From: Barber, Robert [REDACTED]
Sent: 05 May 2017 17:04
To: Claire Potts
Subject: RE: *Ext: RE: FP/19/17/DOC

Following my email earlier this week, please see attached revised drawings to supplements the hard landscaping requirements of condition 12.

I hope you are well. We still obviously have a way to go in terms of our clearing all outstanding conditions relating to consent FP/102/16/PL. As I have stressed previously, we are actively working on discharging all outstanding conditions.

drawing: Landscape Proposal

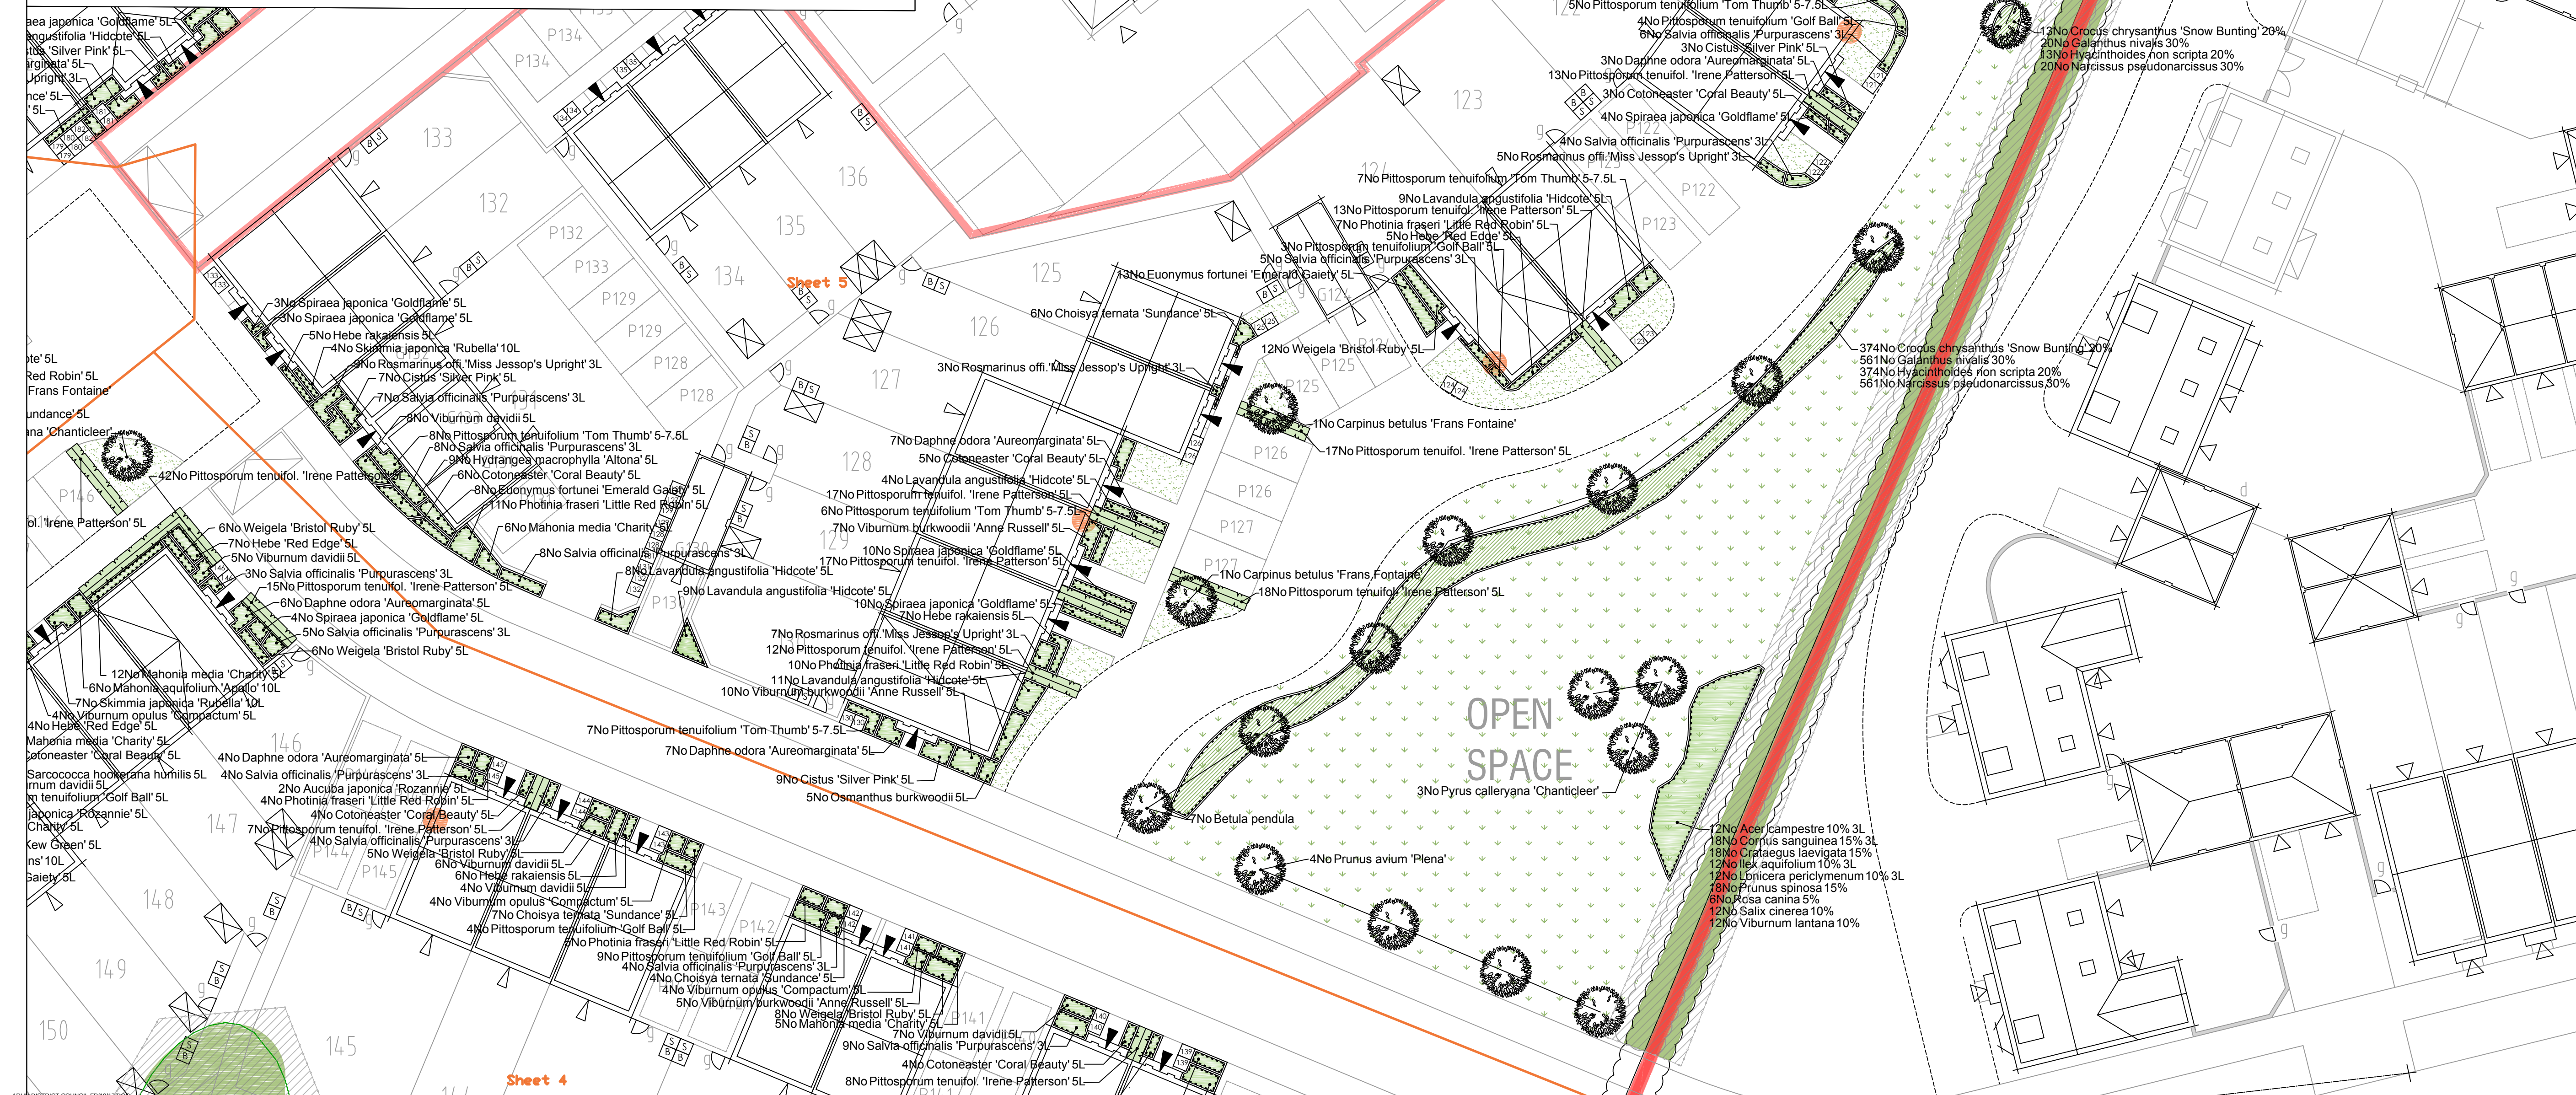
Condition 12 – LA have asked for additional information regarding hard landscaping. Soft Landscaping, no objection Please confirm timing for submission of information

Condition 12 – LA have asked for additional information regarding hard landscaping. Soft Landscaping, no objection.

A	06.05.14	Plot numbers updated.	HJS
REV. No.	DATE	DESCRIPTION	INITIALS
Client	BARRATT		
Project	Phase 5 Bognor Regis		
Title	Section 38 Layout Sheet 2 of 2		
Scale	1:500@A1	Date	Nov'12
Checked		Drawn	JK
Drawing No.	4348:501	Rev	A

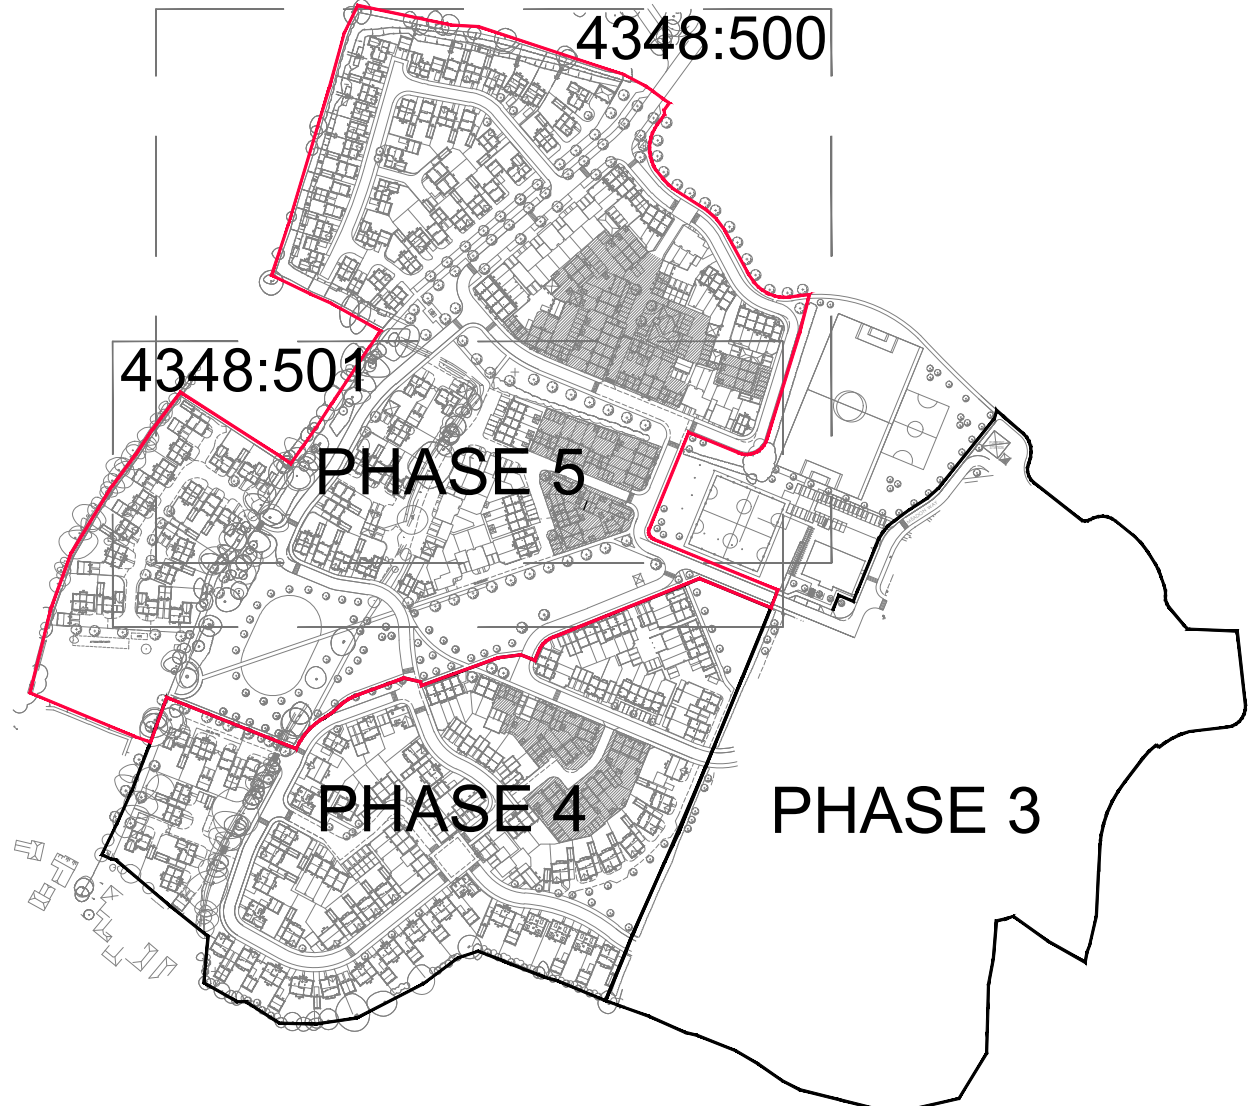
Condition 17 – Submitted to the LA awaiting confirmation of discharge and details. I've reviewed the engineering layouts which show the location of the lighting proposed. I need to see additional details of the lighting units to demonstrate how it meets the requirements of the ecology Report – “avoid lighting up retained boundary woody habitat, using downward facing, directional and low spread lighting adjacent to boundary features and trees.”
